File: SF15/31237
Job ID: DOC15/423606
Your Ref: SSD6957

RE: Heritage Division comments on Response to Submissions for State Significant Development Application 6957 – Crown Sydney Hotel Resort, Barangaroo South.

Location: CREMORNE POINT  
 Camera R.L. 6.50m  
 MGA coords: X: 336260.81, Y: 6253382.67  
 Lens: 40mm  
 Dimensions: 5616 x 3744  
 Date: 14/11/2013, 11:11:55 AM  
 Camera: Canon EOS 5D Mark II

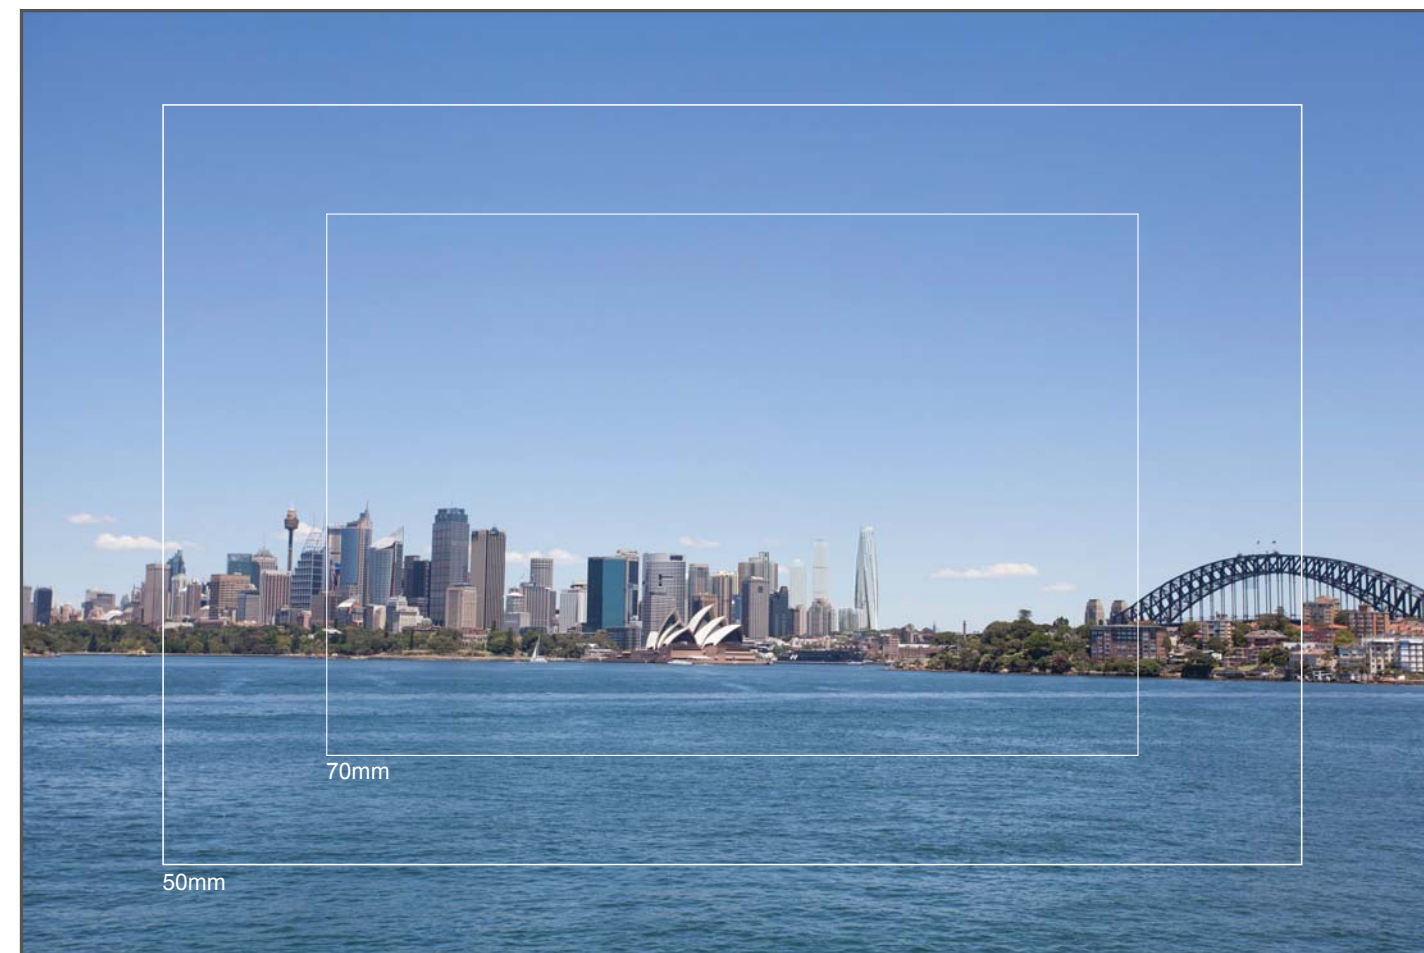
The Visual Impact Photomontage Study demonstrates that the proposed Crown Sydney Hotel Resort Building would be a prominent element in views from all of the chosen camera locations, including areas within Millers Point and longer views within and around the Harbour. The development would therefore substantially alter the character and skyline profile of Millers Point and its surrounding area, including long views of Sydney Harbour foreshore from various vantage points. Furthermore the design and scale of the building does not contribute to the heritage values of Millers Point or other heritage items in the vicinity and it is not considered to have a positive impact.
